# Rezoning Transportation Analysis

Petition Number: 2021-174

Date	Description
11-22-21	First Review (TM)
12-17-21	Second Review (WB)

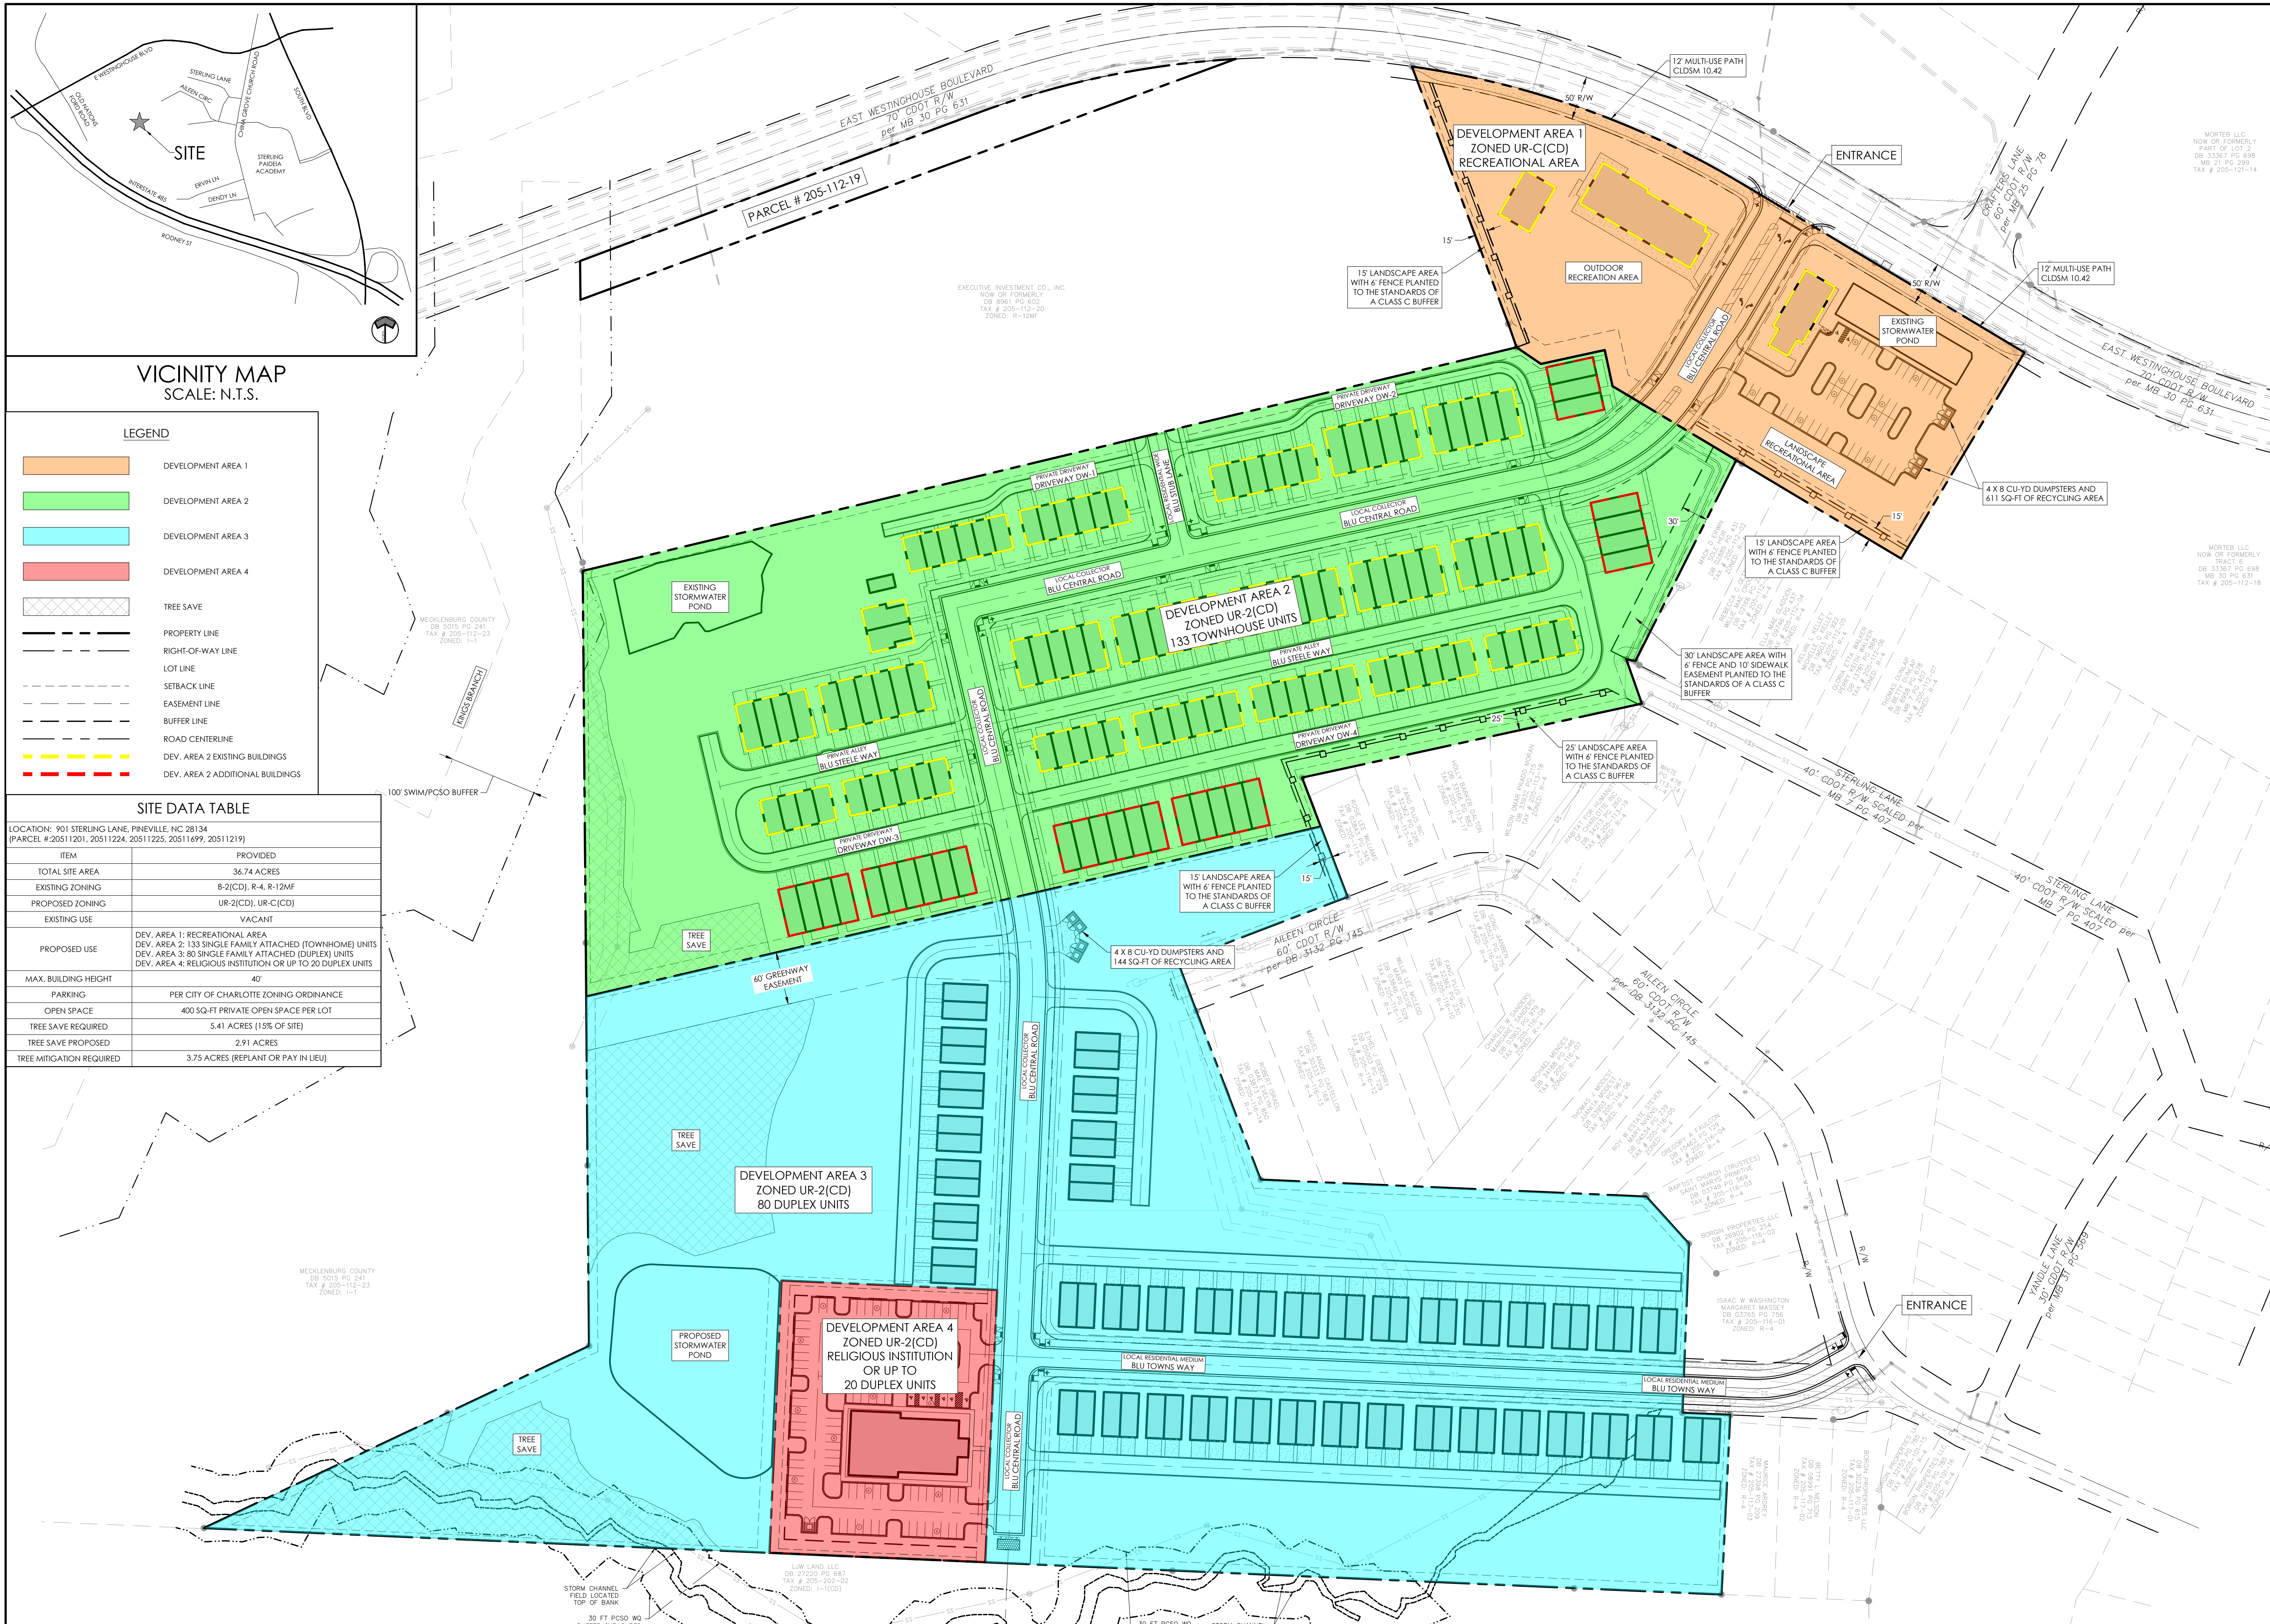
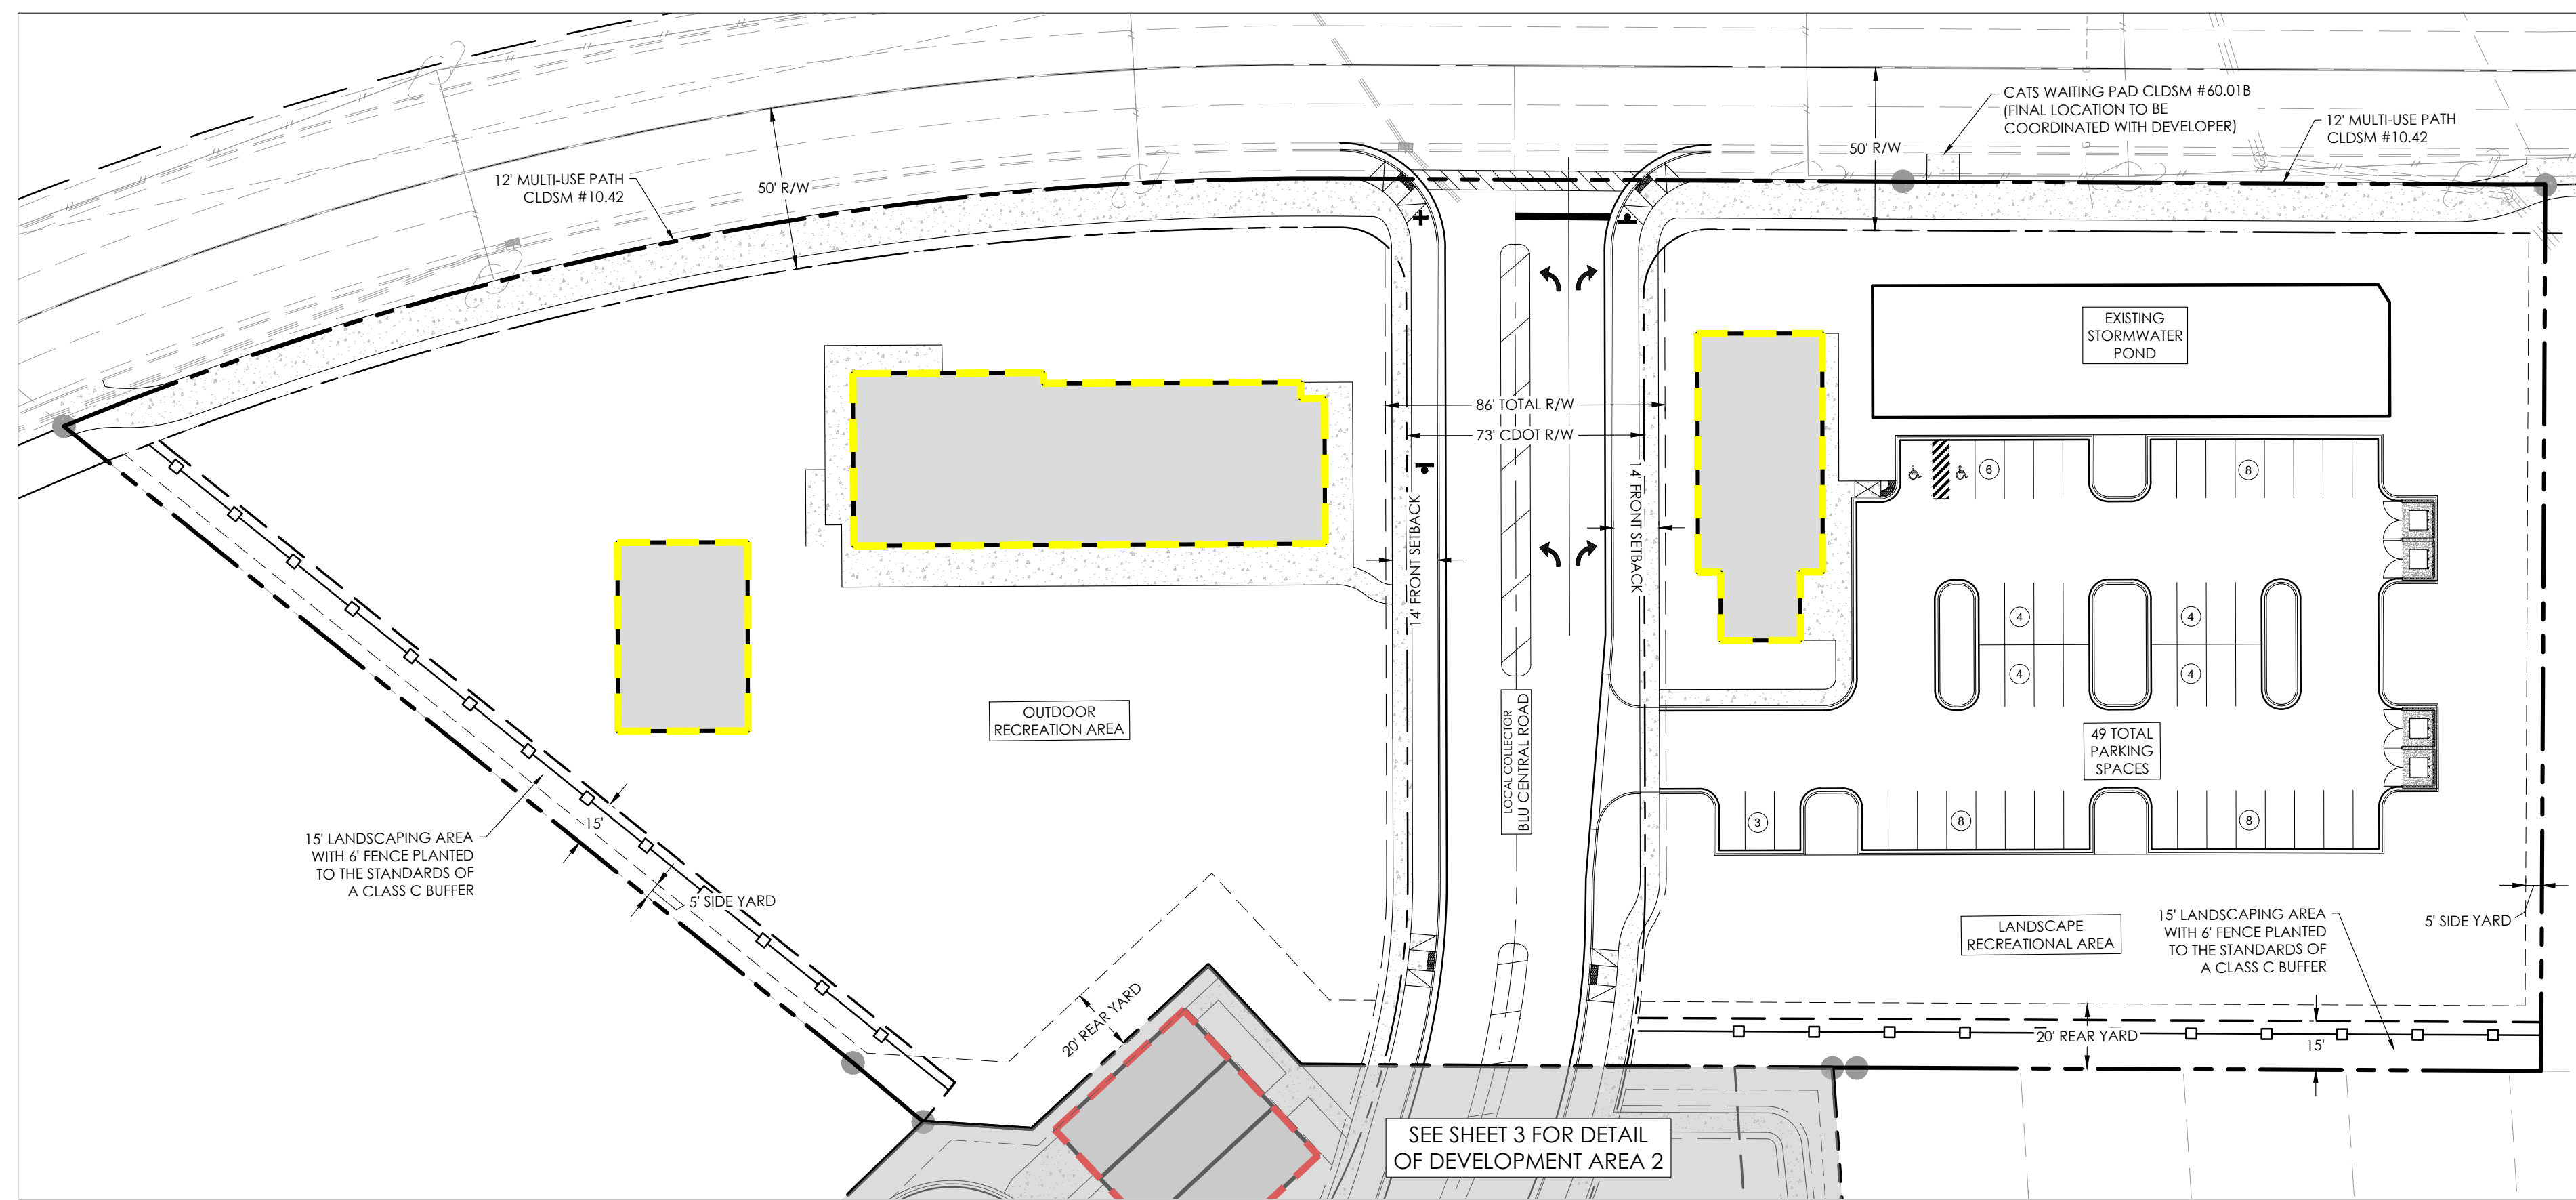
1. **Curblines:** The proposed zoning district has a setback measured from back of the future curblines.
  - a. **East Westinghouse Boulevard:** The future back of curb and gutter shall be installed at 33 feet from the existing street centerline. Revise site plan to show the future back of curb.

Label and dimension the existing and future curb and gutter from the centerline for each road on the site plan.

- ~~3. Revise site plan and conditional note(s) to commit to dedicate 50' right-of-way from the road centerline. The site plan shall label and dimension the right-of-way from the road centerline on East Westinghouse Boulevard.~~
4. Revise site plan to extend Aileen Circle to Blu Central Road as a Local Residential Medium street per CLDSM U-02.
